HIGHWAY AND LEAD LOCAL FLOOD AUTHORITY RESPONSE TO CONSULTATION ON THE FOLLOWING DEVELOPMENT PROPOSAL

Application number: H02-0832-26

Proposal: Details of Construction Management Plan & Method Statement, Estate Road Phasing & Completion Plan and details of installation of fire hydrants (Conditions 14, 17 & 29 of H02-0759-25)

Location: Land East of Normanton Road, Crowland

Appendix A: Conveyance Plan

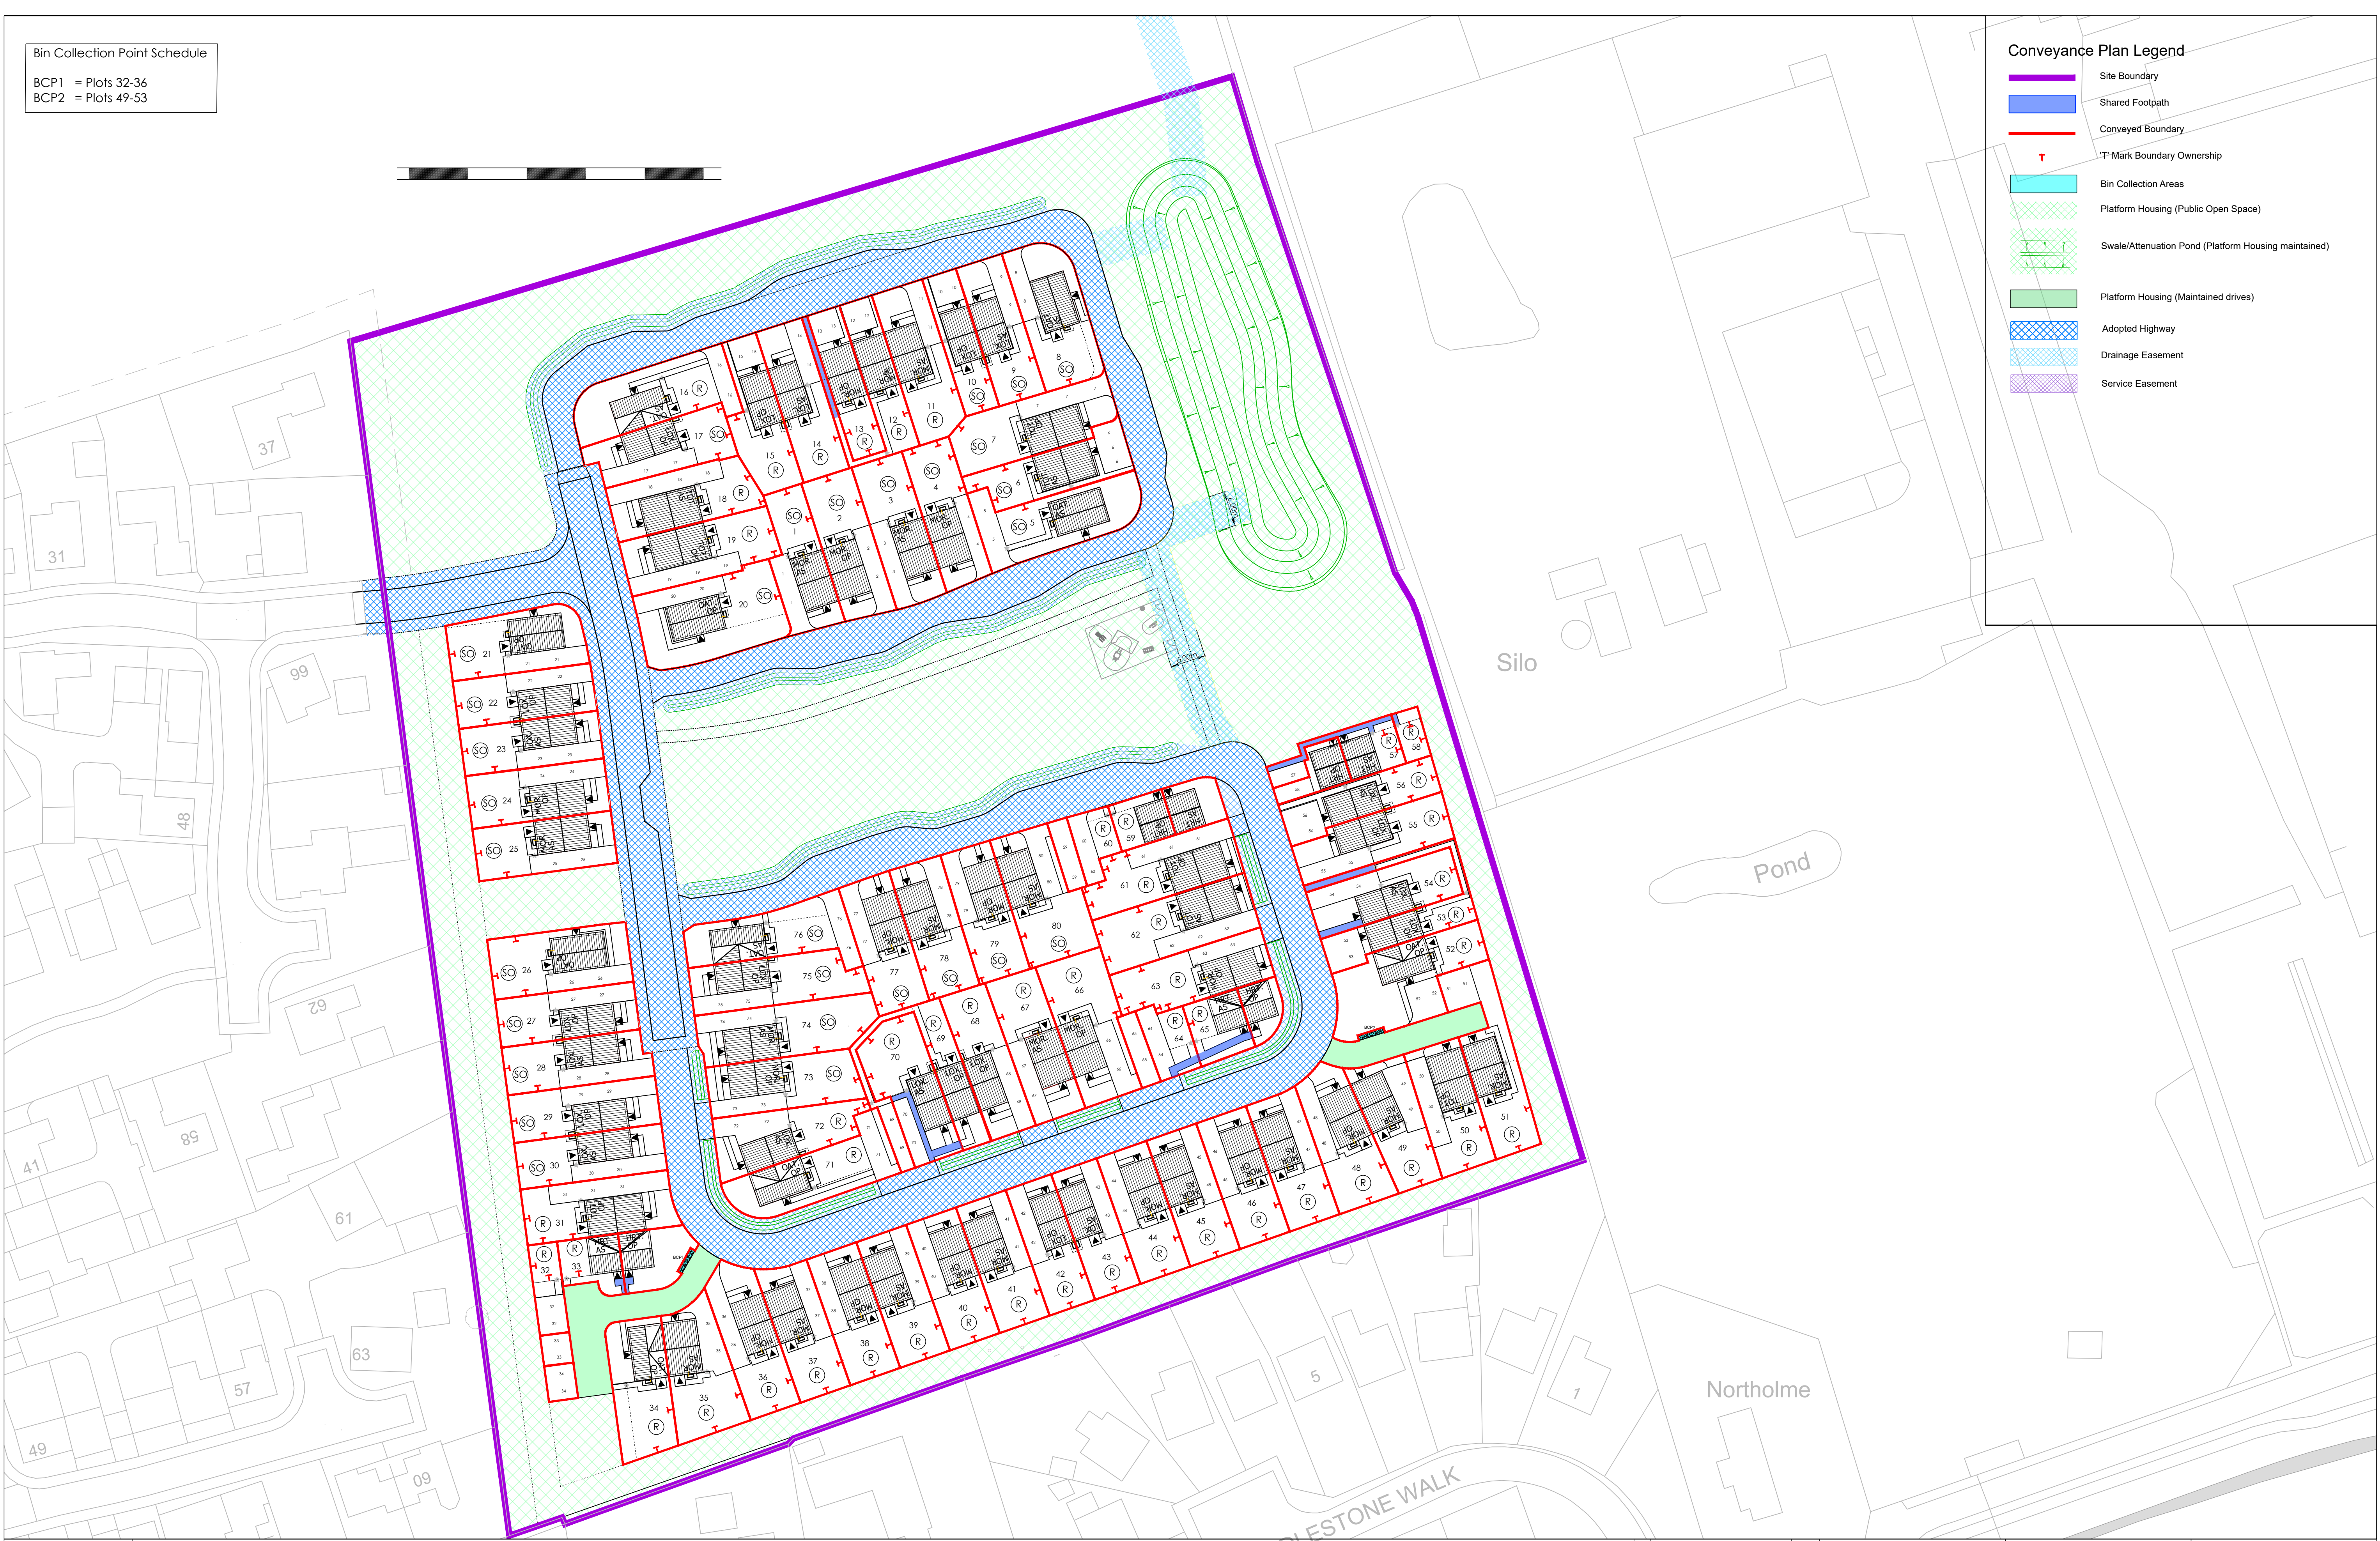
In respect of Condition 17, the revised Street Management & Maintenance Plan has corrected the previous drafting errors, identifies the proposed maintenance responsibilities, conveyance arrangements, construction sequence and measures for management of the estate roads during the construction period. The submitted information is considered sufficient to satisfy the requirements of the condition.

DRAWING NO.
E0275-CMP-02

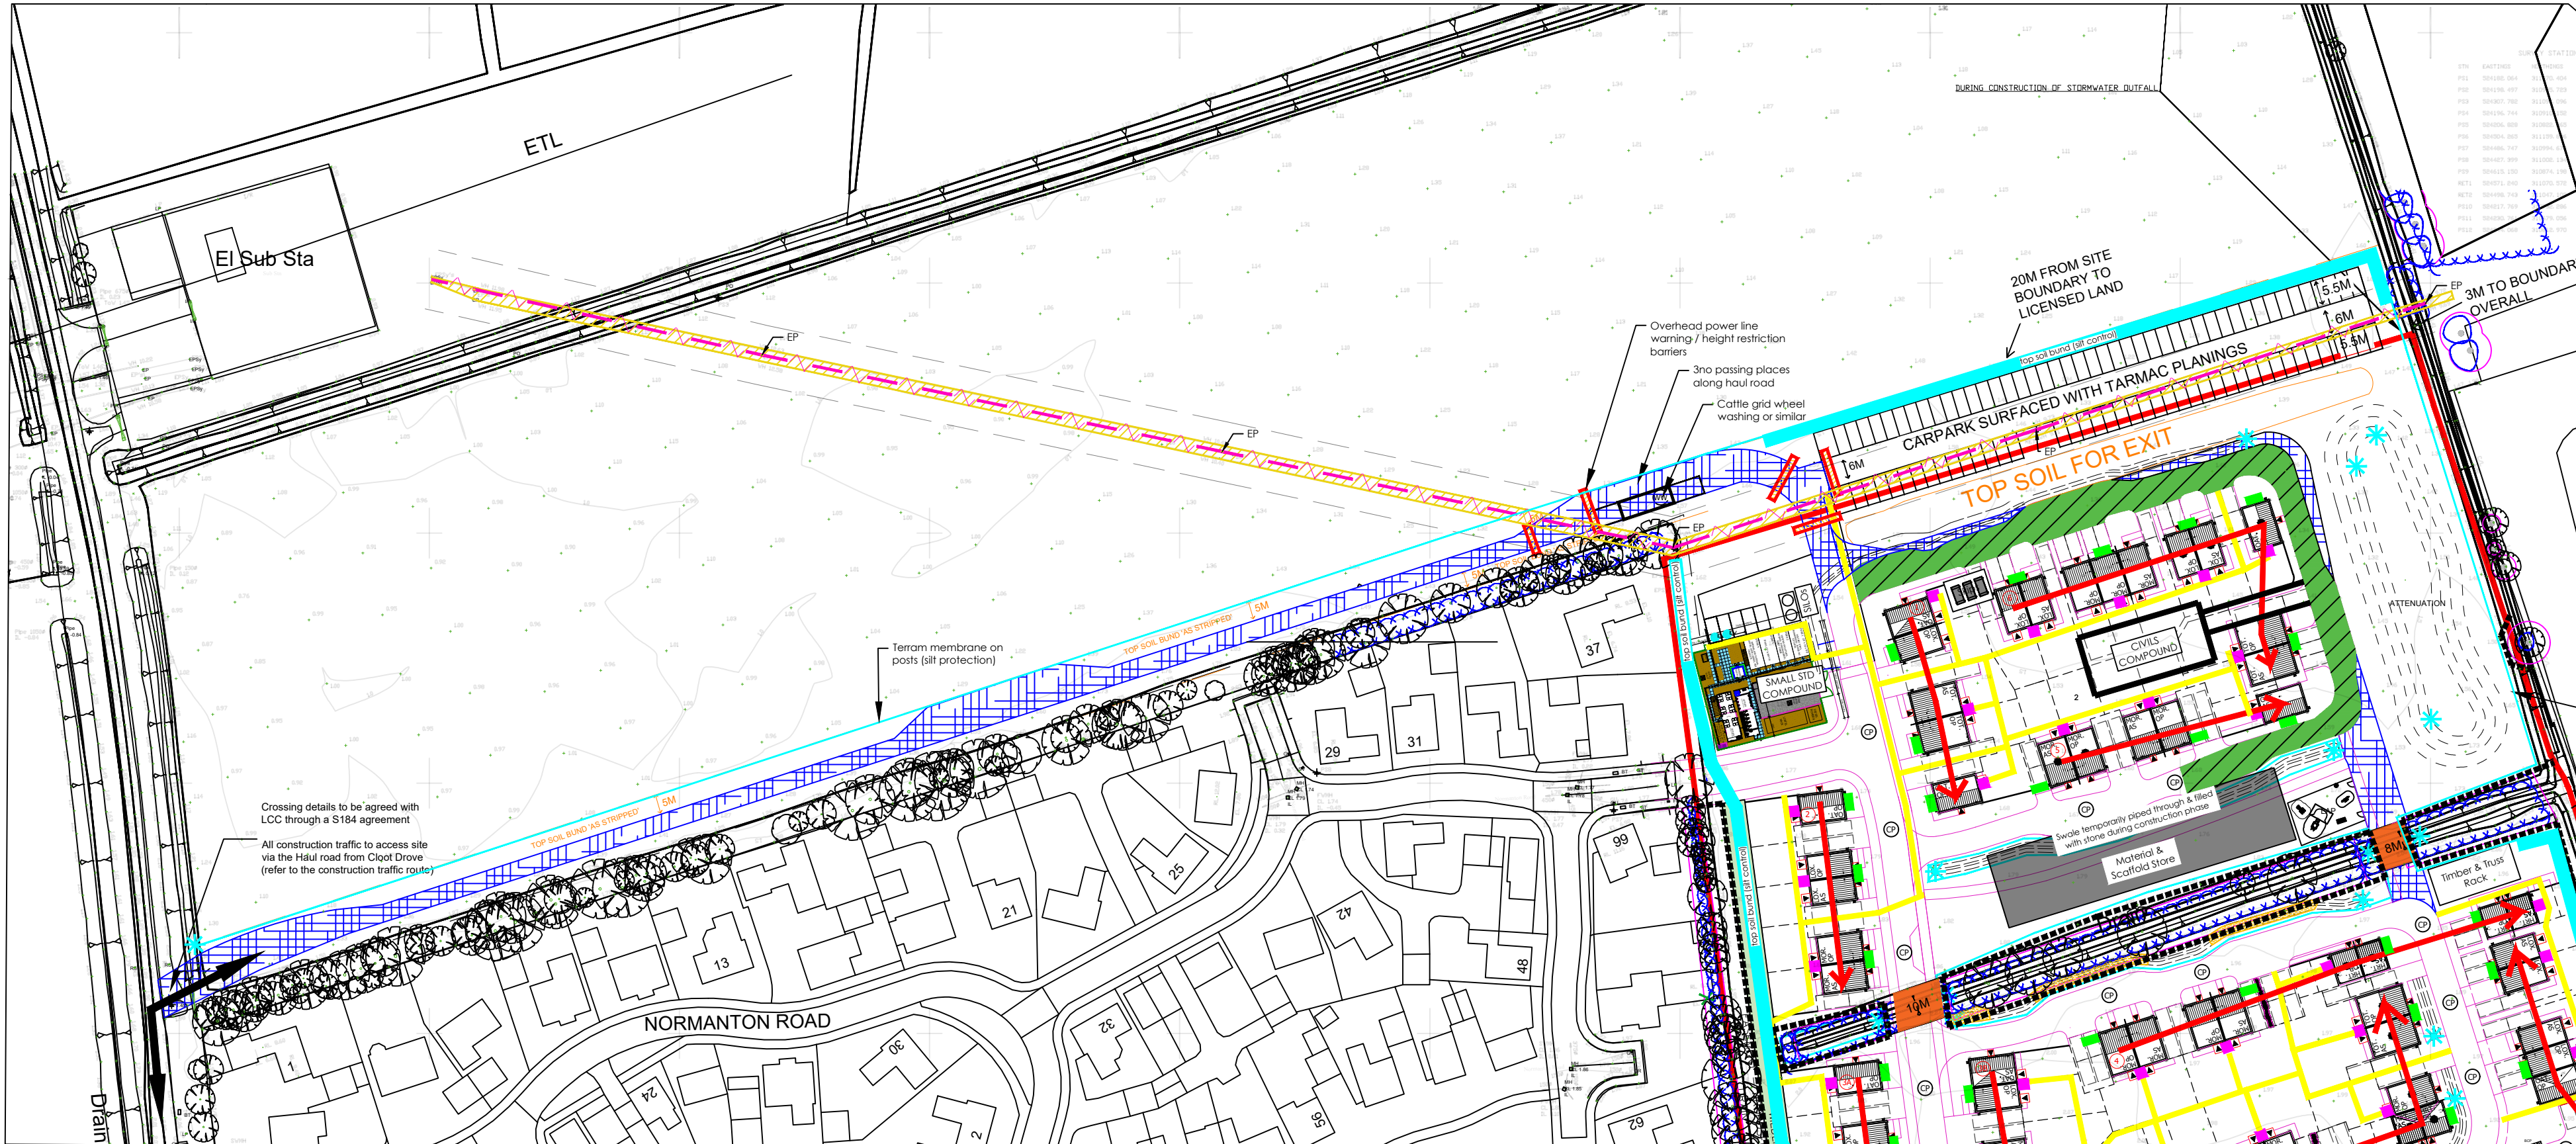
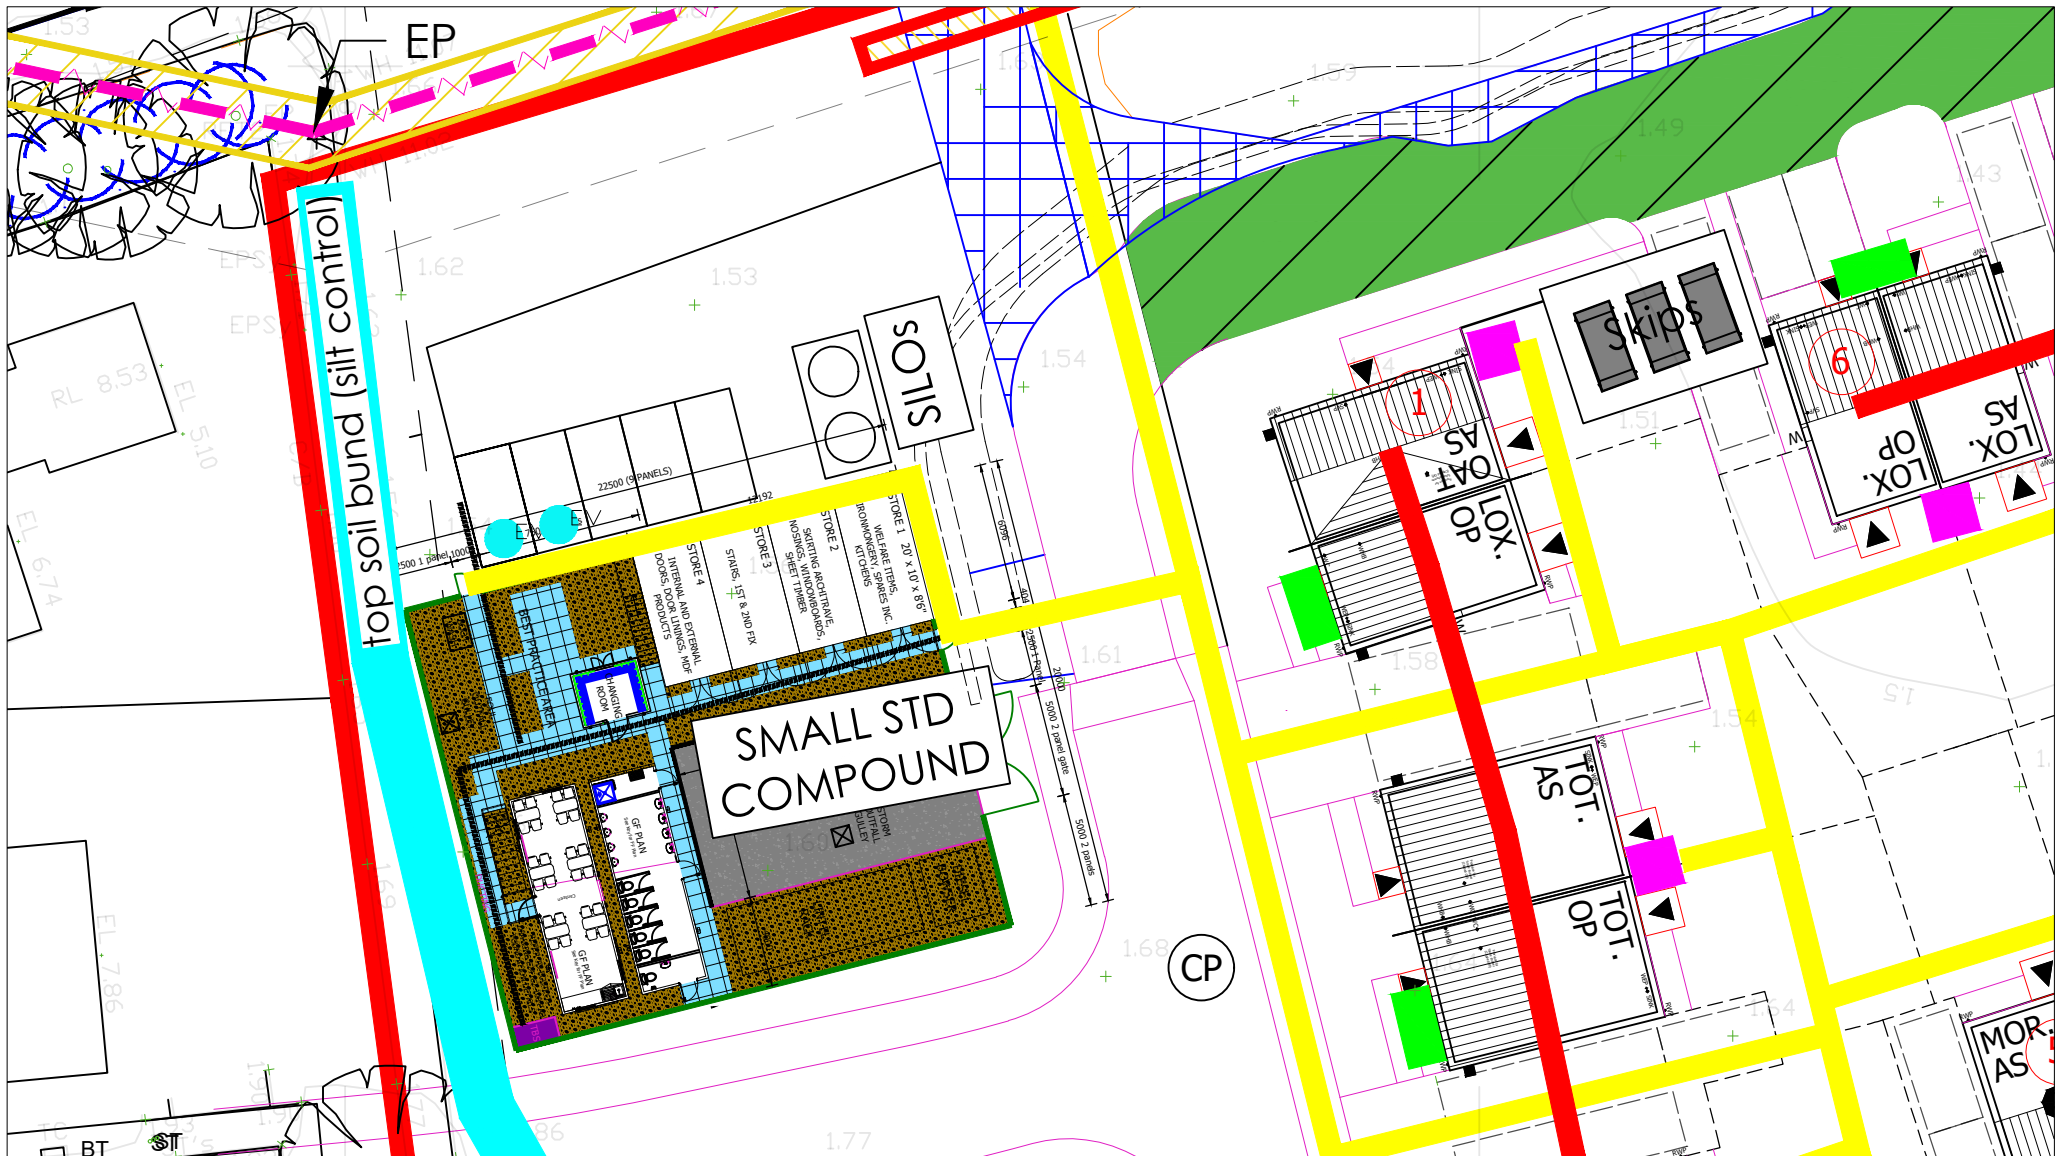
In respect of Condition 14, the revised Construction Management Plan now identifies a single construction access and routing arrangement via the haul road from Clout Drove, provides details of haul road construction, site parking, loading and unloading arrangements, wheel washing facilities, construction traffic routing and measures to minimise disturbance arising from construction activities. The Construction Traffic Management Plan also identifies measures intended to prevent construction traffic from travelling through Normanton Road.

The condition requires a strategy stating how surface water runoff on and from the development will be managed during construction, together with protection measures for sustainable drainage features and drawings showing how drainage systems connect to an outfall during construction. The revised submission includes a construction-stage surface water strategy identifying silt control measures, protection of drainage features, early delivery of the attenuation basin, provision of an operational outfall prior to plot connections, and drawings showing the relationship between the proposed drainage measures and construction works. Whilst the information is not as detailed as would normally be sought through a dedicated construction-phase drainage management condition, on balance it is considered to satisfy the requirements of the condition as worded.
